**STATEMENT OF ENVIRONMENTAL EFFECTS: SECTION 75W APPLICATION TO MAJOR
PROJECT MP NO.08_0257 STAGE 1 (BUILDINGS 4 & 5) – 61 MOBBS LANE, EPPING**

Pursuant to Section 75W (1) (a) of the Environmental Planning and Assessment Act 1979, a 'modification of approval' is sought to vary Condition No. A2 pertaining to Major Project MP No. 08_0257 Stage 1 (Buildings 4 & 5) as approved on the 15 September 2010. The modification is to amend architectural plans to accommodate minor design changes to the approved architectural plans arising from design and construction compliance.

Title Building 4 Ground Floor Plan

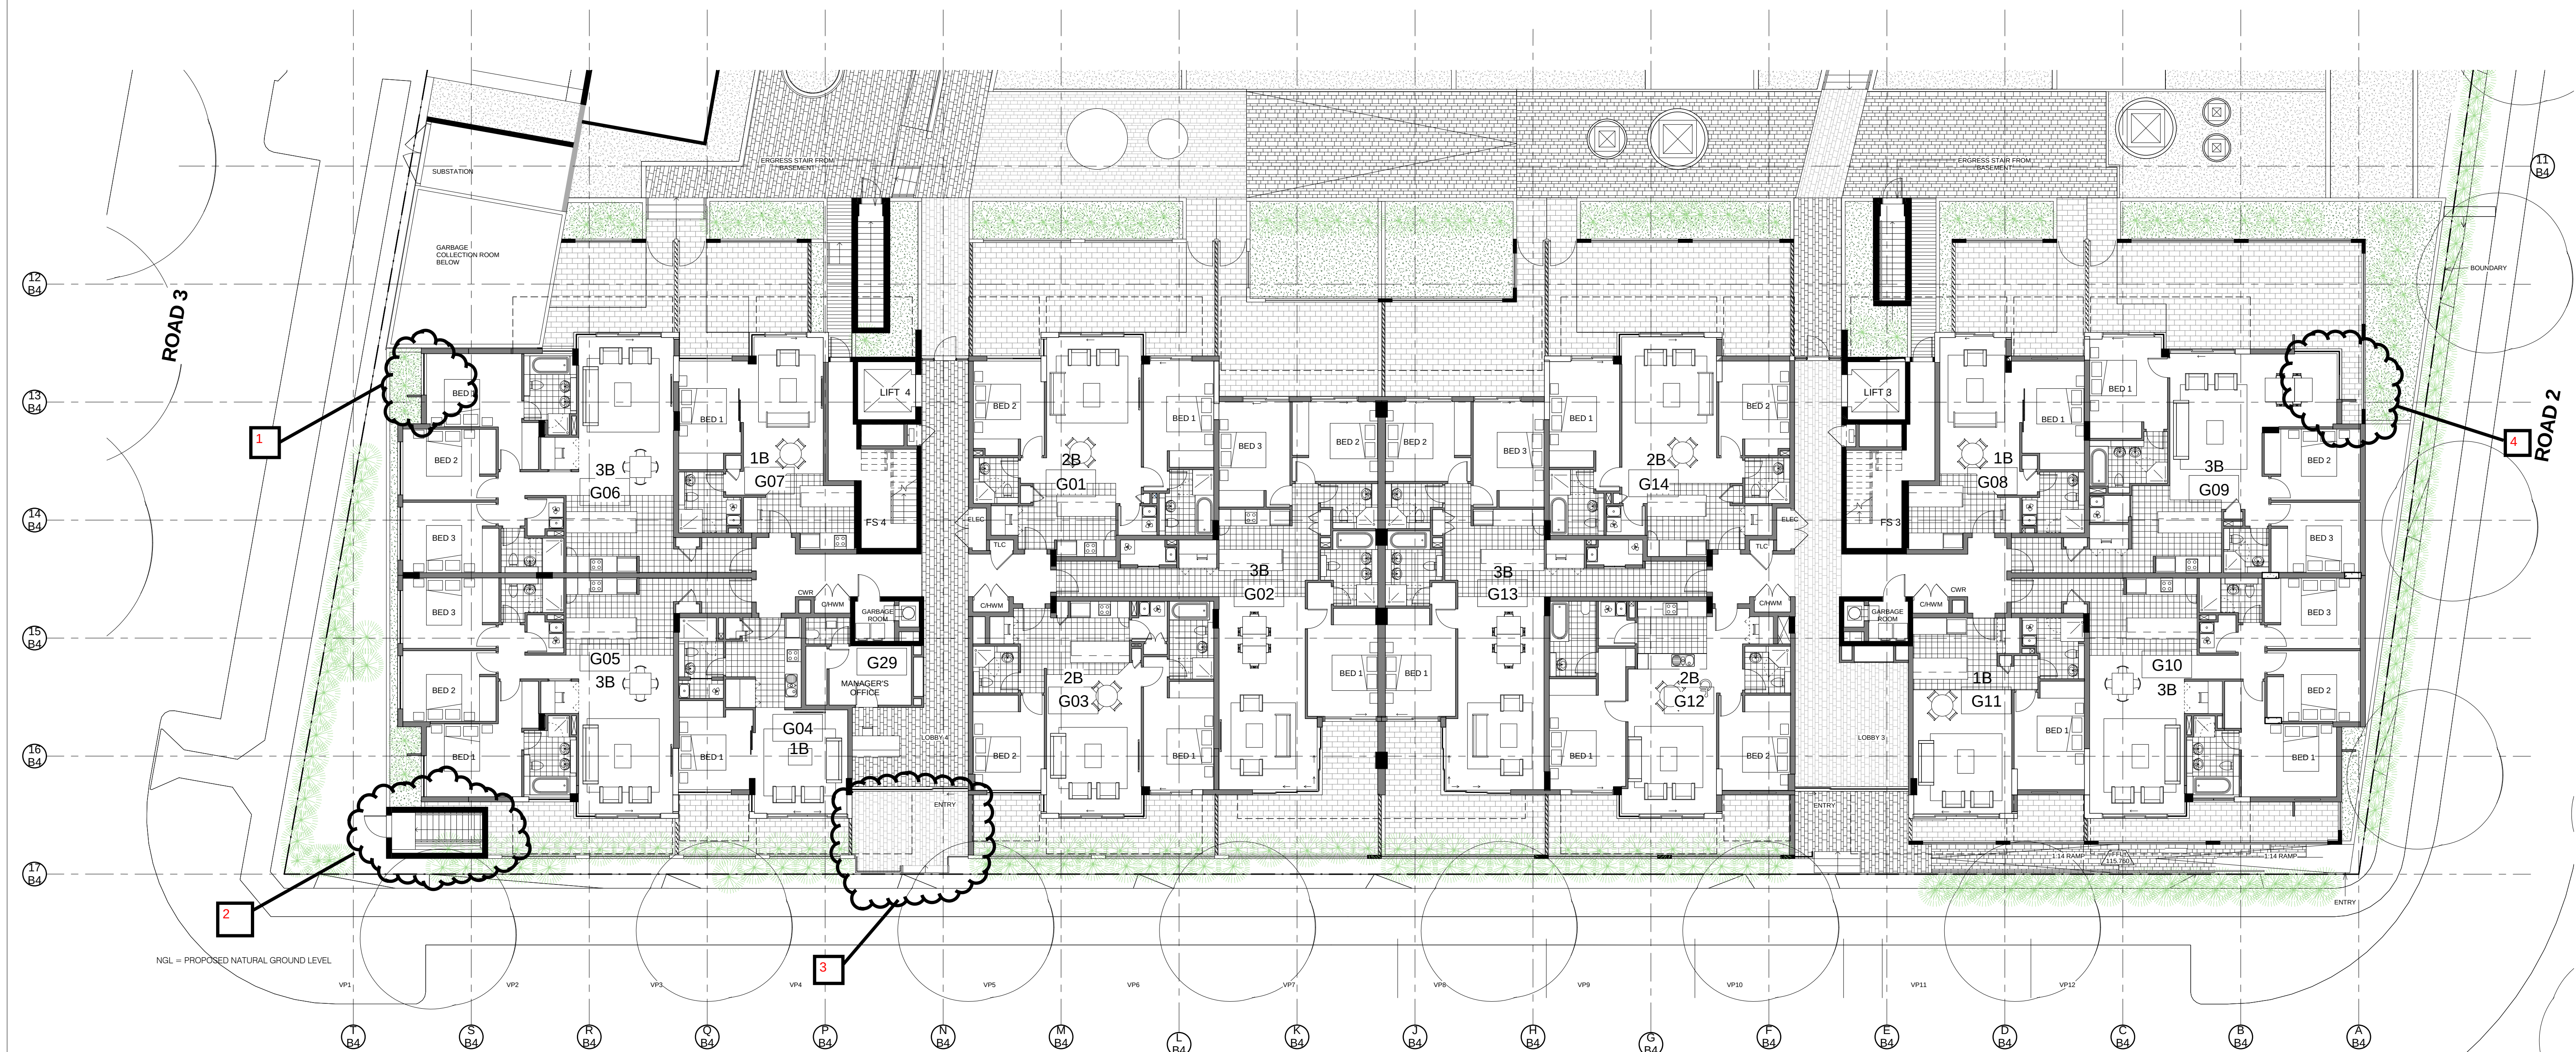
1. Unit G06 : delete window and brick up space
2. Unit G05 : change orientation of stairs
3. Unit G04 : delete stairs and replace with landscape area
4. Unit G09 : reduce size of window

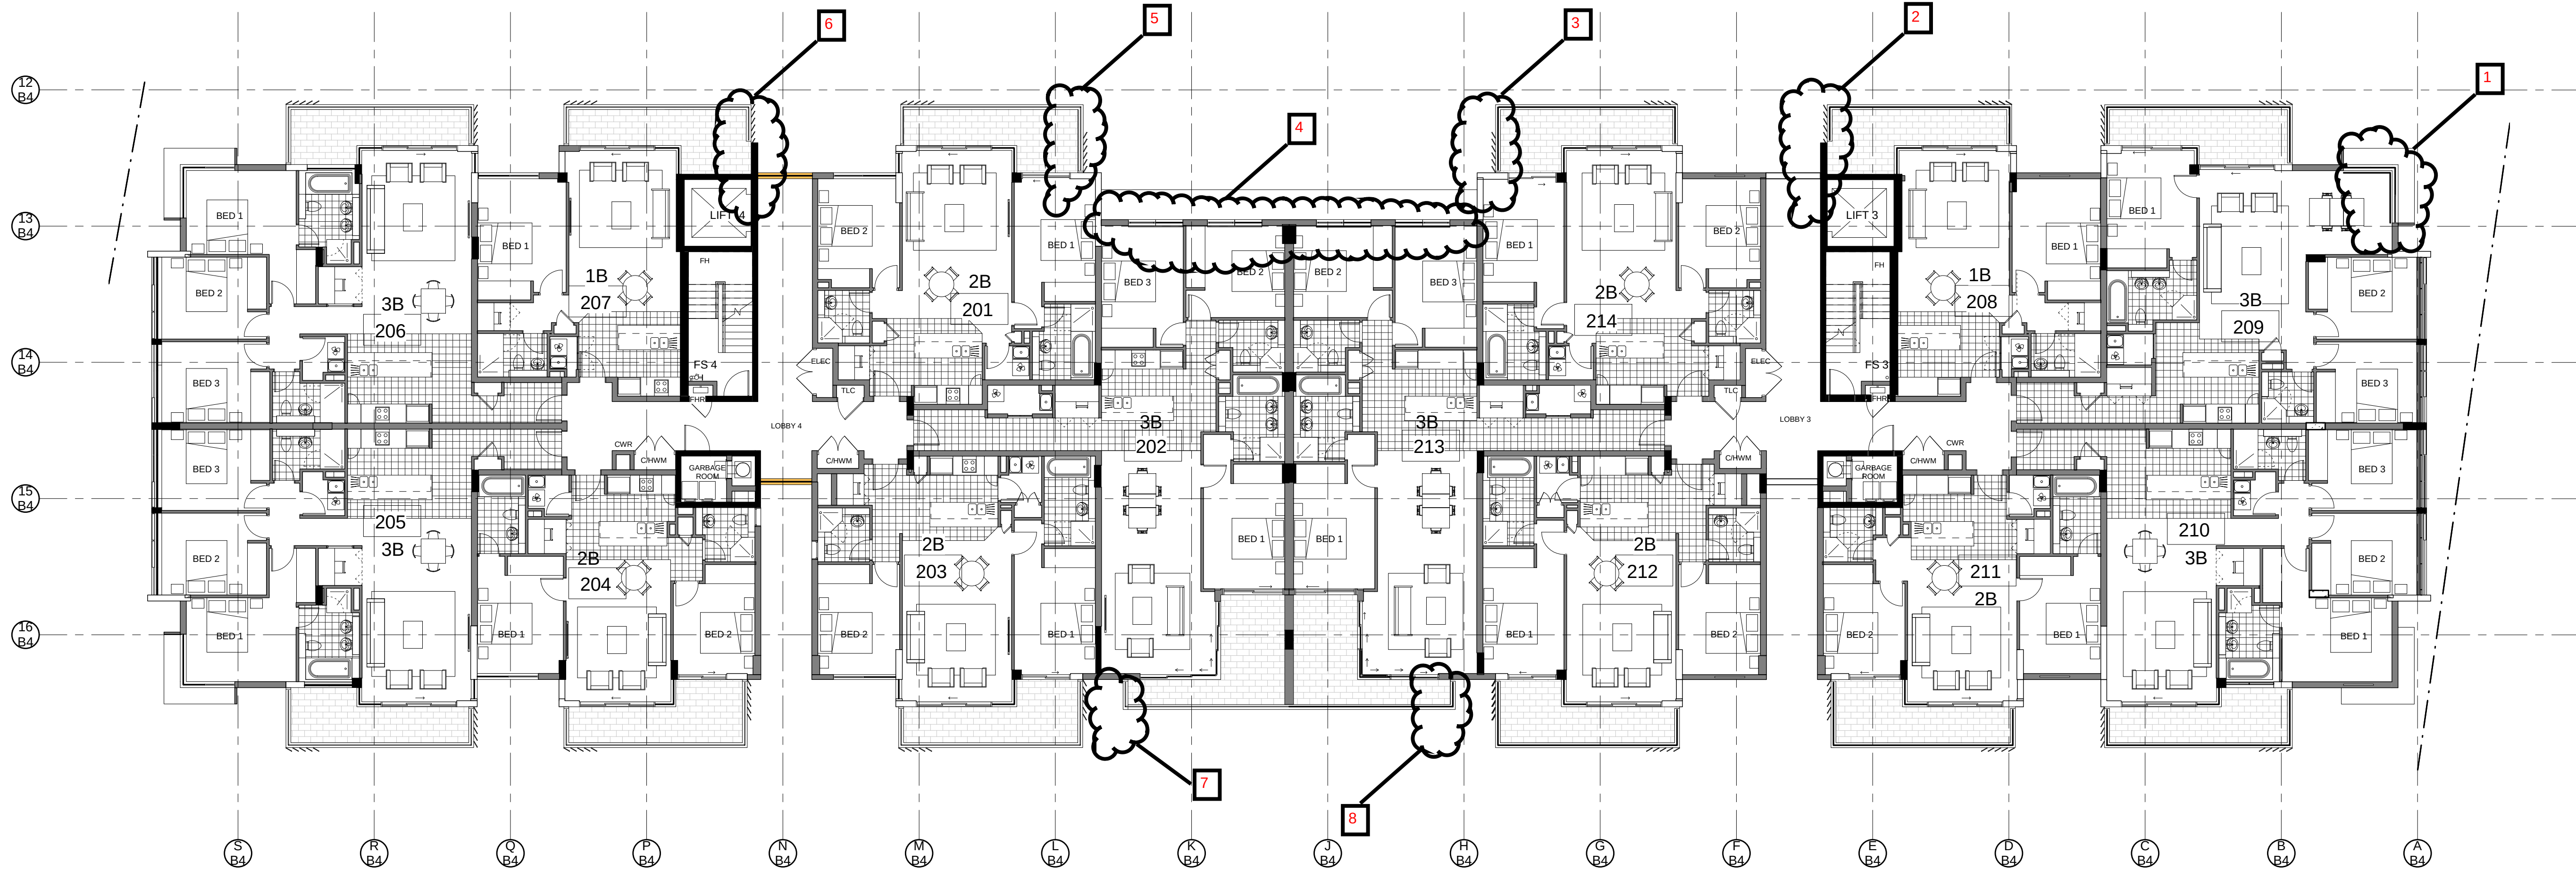
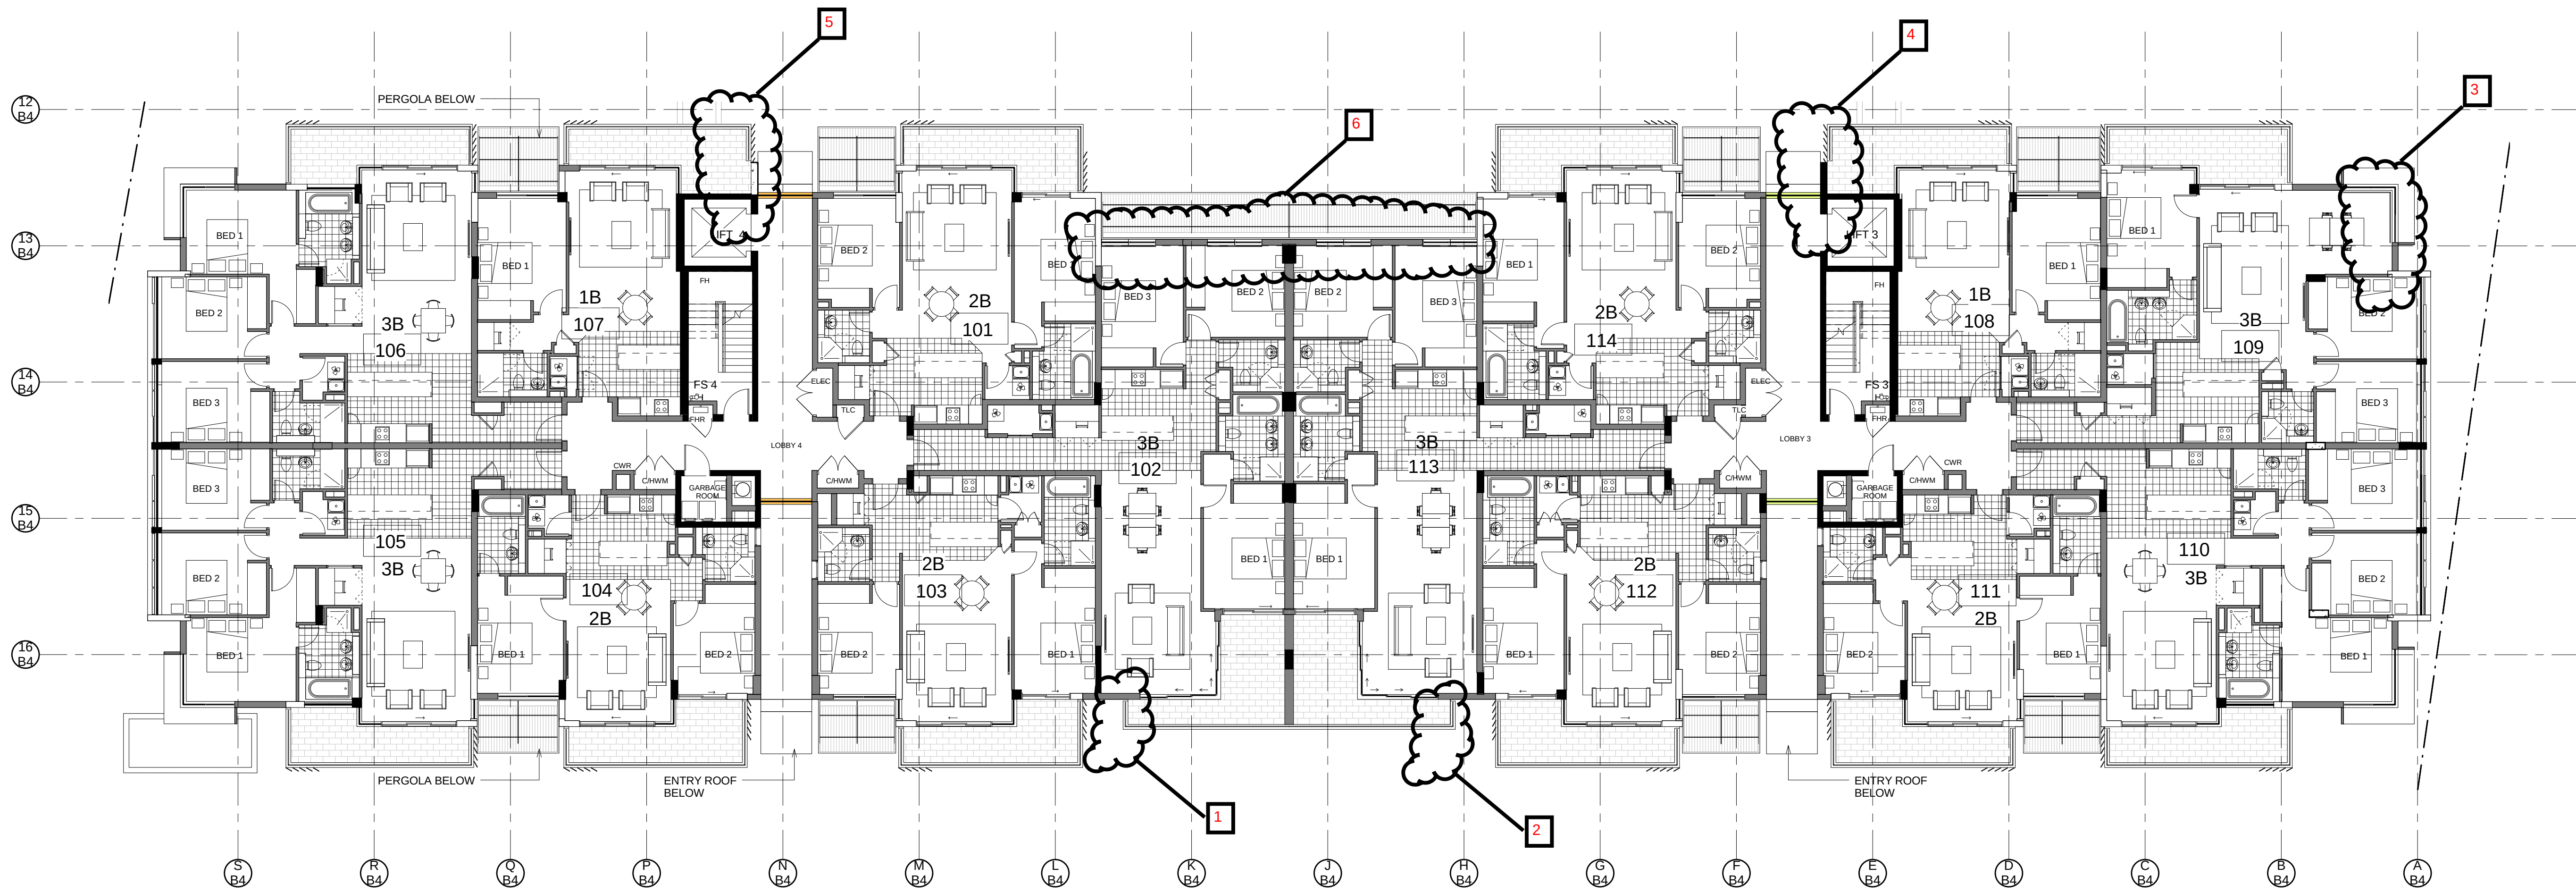
1. Unit 102 : increase precast panel size by 450mm
2. Unit 113 : increase precast panel size by 450mm
3. Unit 109 : reduce size of window
4. Unit 108 : new louvre and concrete wall configuration
5. Unit 107 : new louvre and concrete wall configuration
6. Units 102 and 113 : amend precast panel and window configuration

1. Unit 209 : reduce window size and awning
2. Unit 208 : new louvre and concrete wall configuration
3. Unit 214 : new louvre and concrete wall configuration
4. Unit 213 : reconfigure window and concrete panel
5. Unit 201 : new louvre and concrete wall configuration
6. Unit 207 : new louvre and concrete wall configuration
7. Unit 202 : louvers deleted
8. Unit 213 : louvers deleted

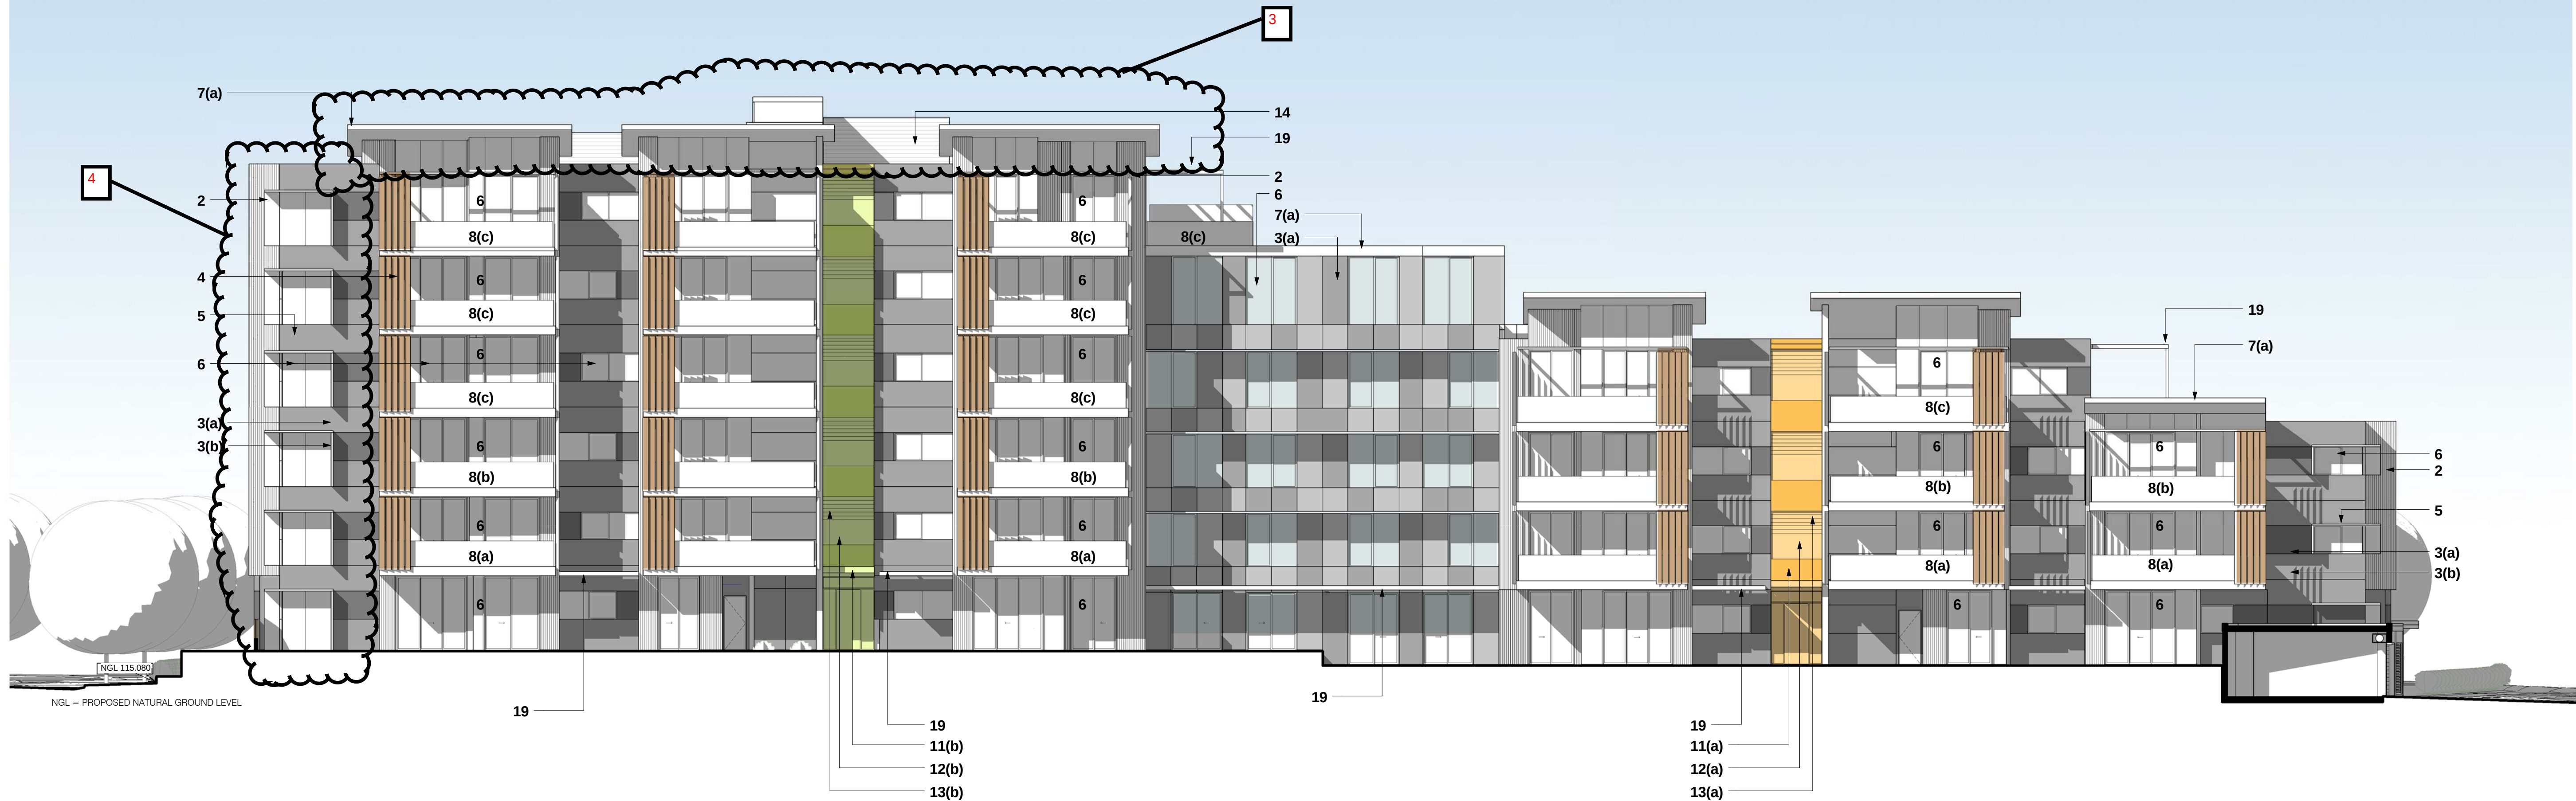
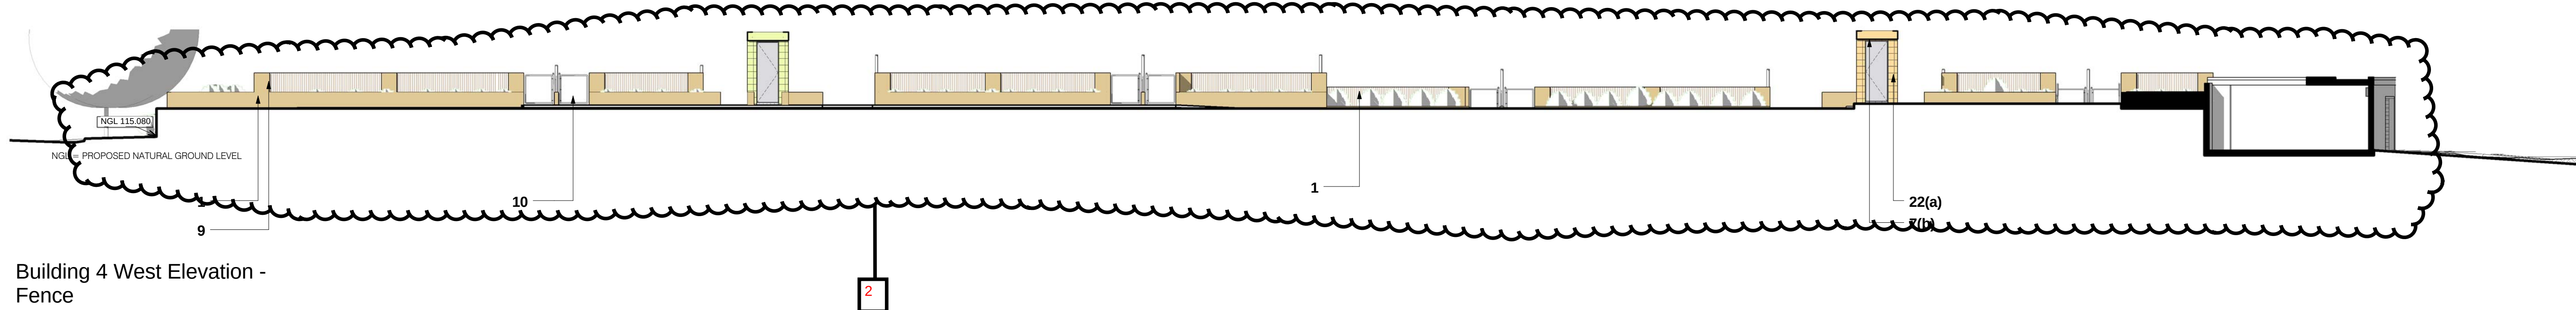
1. Change fencing from timber to aluminium
2. Insert elevation of proposed fencing
3. Roof details amended
4. Amended awnings and window configuration
